**SECTION 4.55(1A) MODIFICATION APPLICATION (SSD 7173 MOD 5) FOR PROPOSED AMENDMENT TO THE SUBDIVISION PLAN**

**PROPERTY AT: 585-649 MAMRE ROAD, ORCHARD HILLS (LOT 2171 DP 1153854)**

Proposed Amendment to the Subdivision Plan – Proposed Lots 10, 11 & 12, 585-649 Mamre Road, Orchard Hills

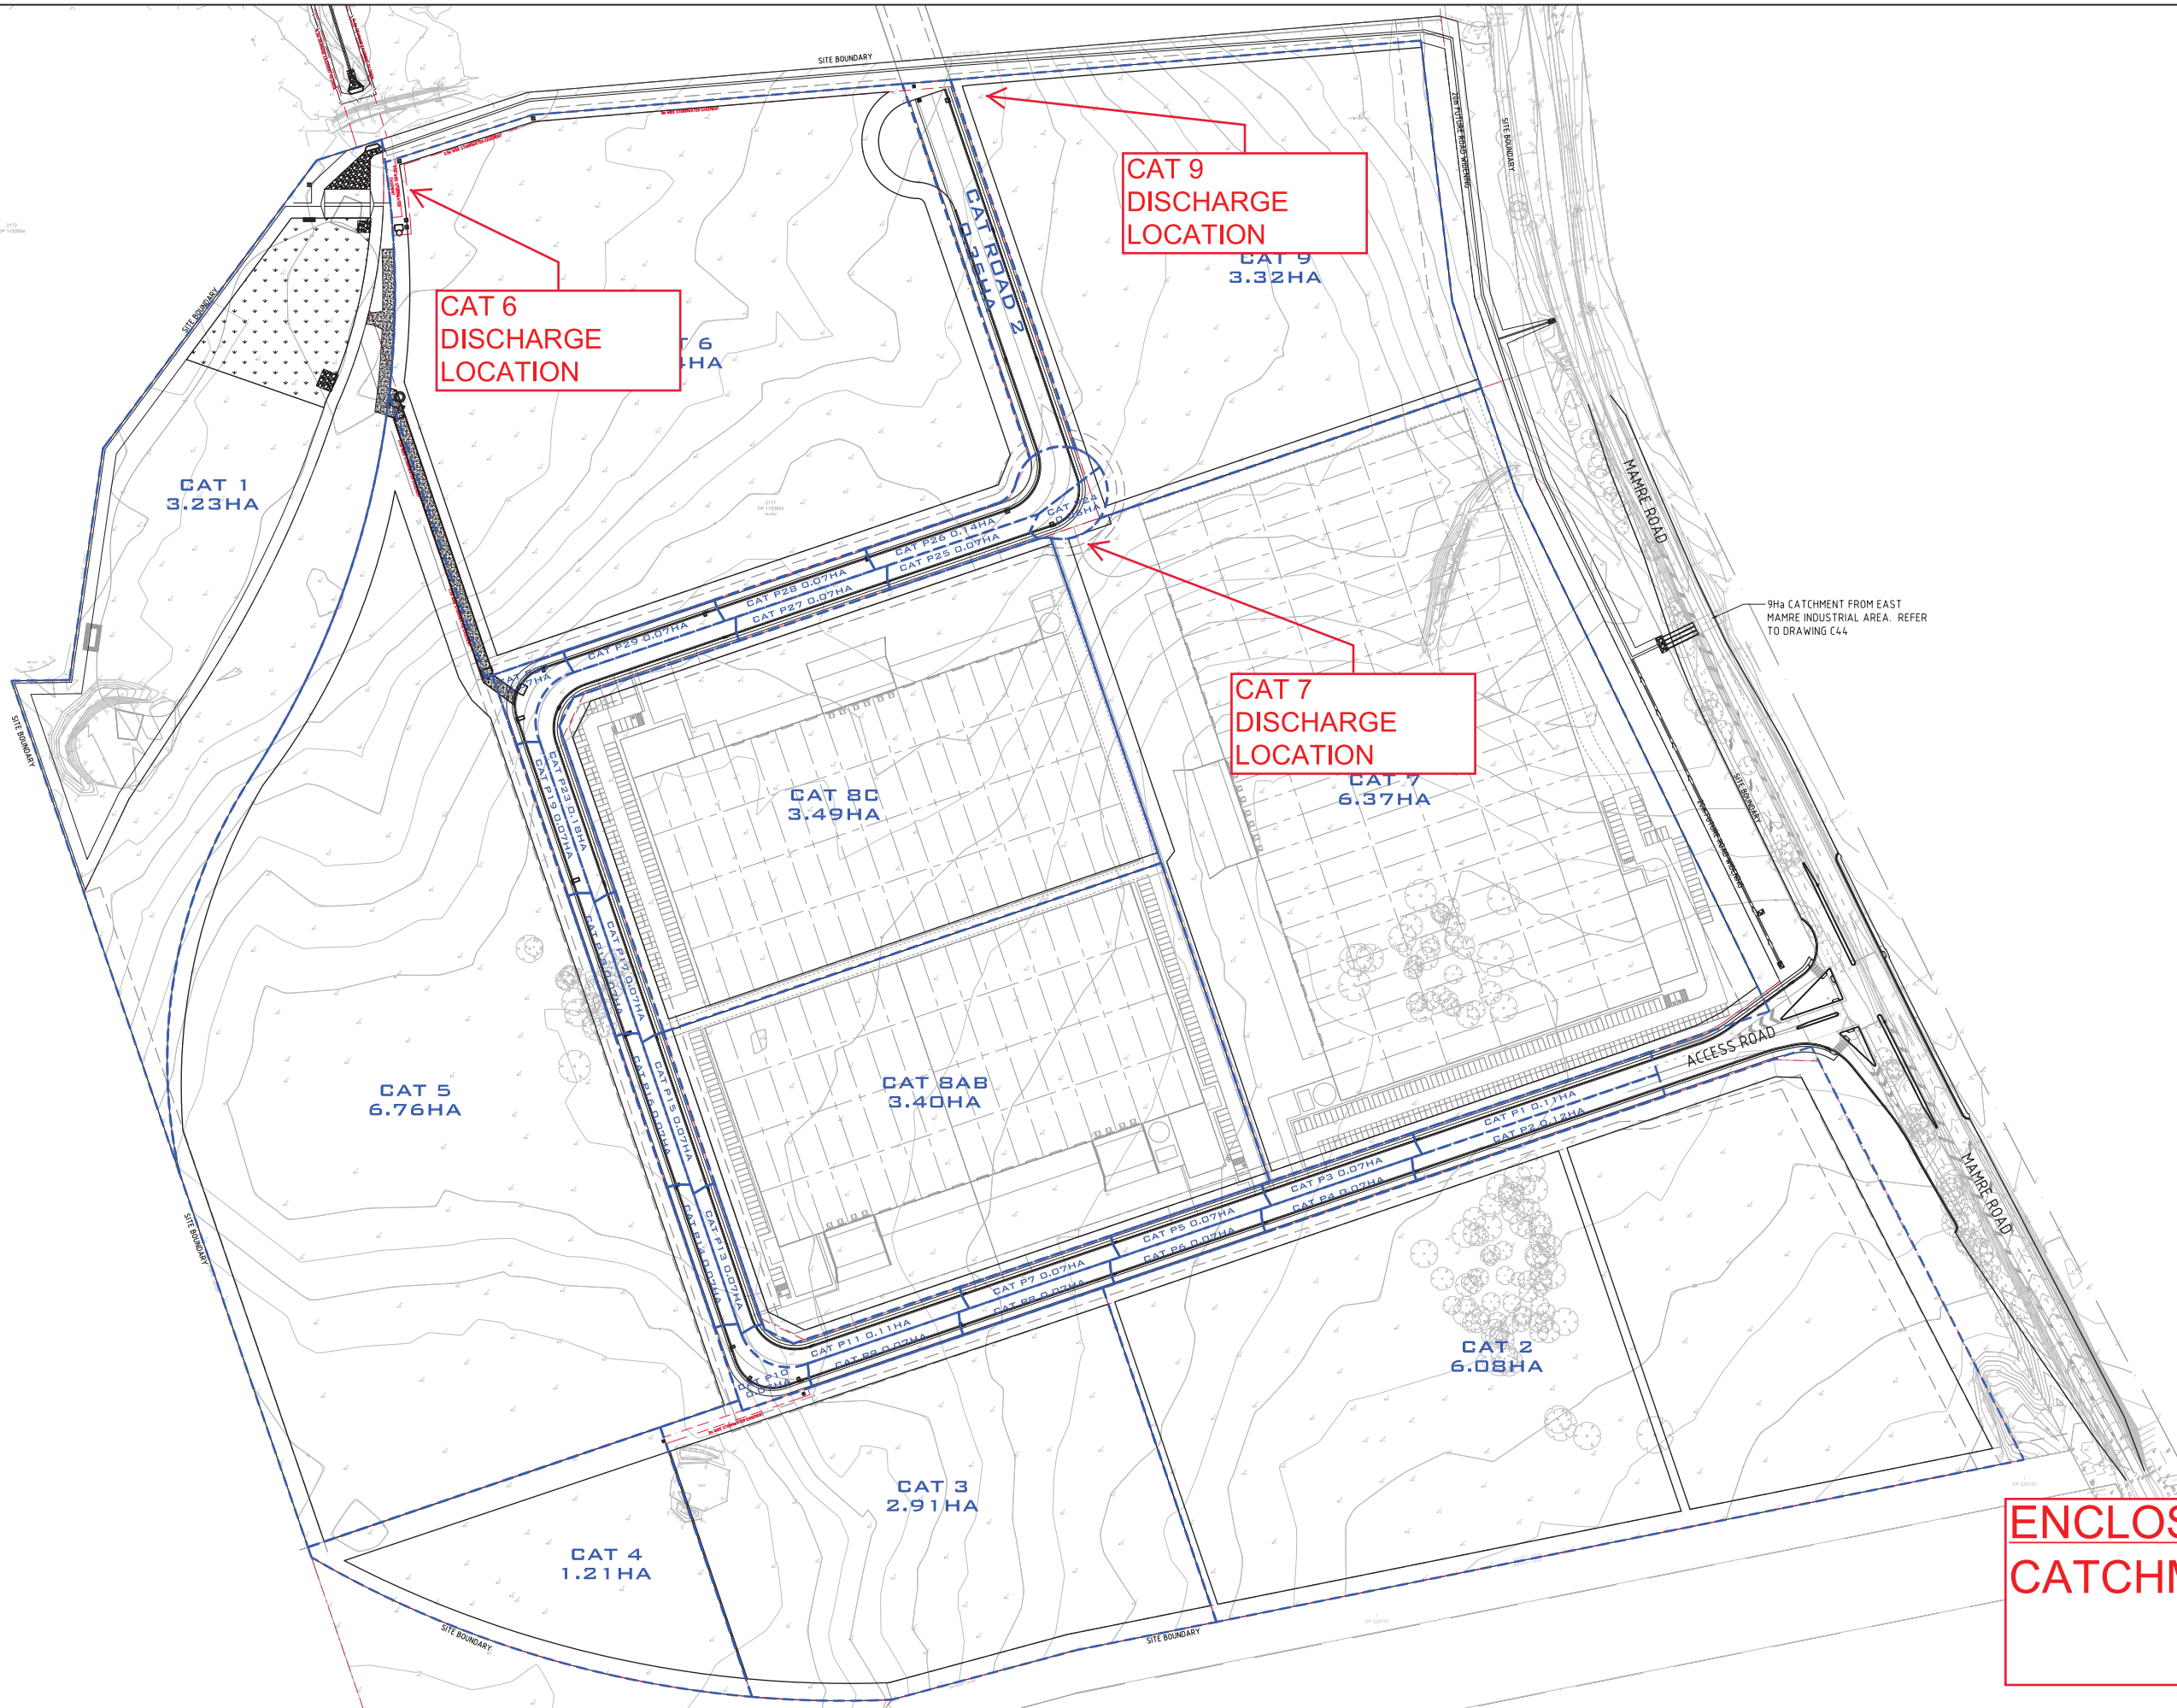
| <p><b>Engineering Considerations:</b></p> <p><u>Severance Area (Lot 12):</u><br/><i>It has been indicated that the proposed lot 12 is not to be serviced at this point in time. However, a lawful point of discharge for stormwater drainage is required and has not been demonstrated to the proposed lot.</i></p> <p><u>Stormwater Plans:</u><br/><i>The proposed Civil &amp; Stormwater Plans as submitted are not civil drawings and appear to be a copy of subdivision plan with hand written drainage notes.</i></p>   | <p>As mentioned above, proposed Lot 12 will be amalgamated with Lot 1 DP 1233392 at a later point in time, for which one (1) allotment would be created. The amalgamation would be undertaken in response to the proposed intersection upgrade proposed, as a result of the widening of Mamre Road. Any current stormwater drainage for proposed Lot 12 would be indicative of previously approved plans provided in SSD 7173 MOD 2 and SSD 9429 (currently under assessment), for which the stormwater drainage is considered satisfactory.</p> <p>Any future development proposed on the amalgamated lot would take into consideration any stormwater drainage requirements, for which civil engineering plans would be designed in accordance with the relevant Council requirements and engineering standards.</p> <p>The Civil Engineering (Stormwater) Letter of Support (refer to <b>Appendix 1</b>), provided by Costin Roe Consulting has been amended to remove any hand-written drainage notes, for which detailed civil engineering plans have been</p> |

| <p><i>A revised civil design drawing with level notations and associated contours is required which details the proposed drainage measures and any earthworks necessary to achieve this drainage scheme.</i></p> <p><i>This also includes the location and width requirements for the identified easement over proposed Lot 10 benefiting Lot 11 and whether the proposal includes the installation of a underground drainage pipe.</i></p> <p><i>The plan(s) should also detail how the amended lot arrangement and indicated catchment splits (as evident within Proposed Lot 10) can be accommodated without additional or revised earthworks to achieve the drainage design as approved.</i></p> | <p>utilised accordingly. <b>Appendix 1</b> is considered to satisfactorily address the proposed amendments to the Subdivision Plan with regard to proposed Lots 10-12.</p> <p>With regard to this Modification Application, the civil engineering design drawings remain consistent with what has been submitted to the NSW DP&amp;E with regard to SSD 9429 for assessment (refer to <b>Appendix 3</b>), as well as being in line with the design drawings that have been previously approved under SSD 7173 MOD 2. There is no intention to change the levels under this Modification Application, for which the Site will continue to drain as previously approved under SSD 7173 MOD 2.</p> |
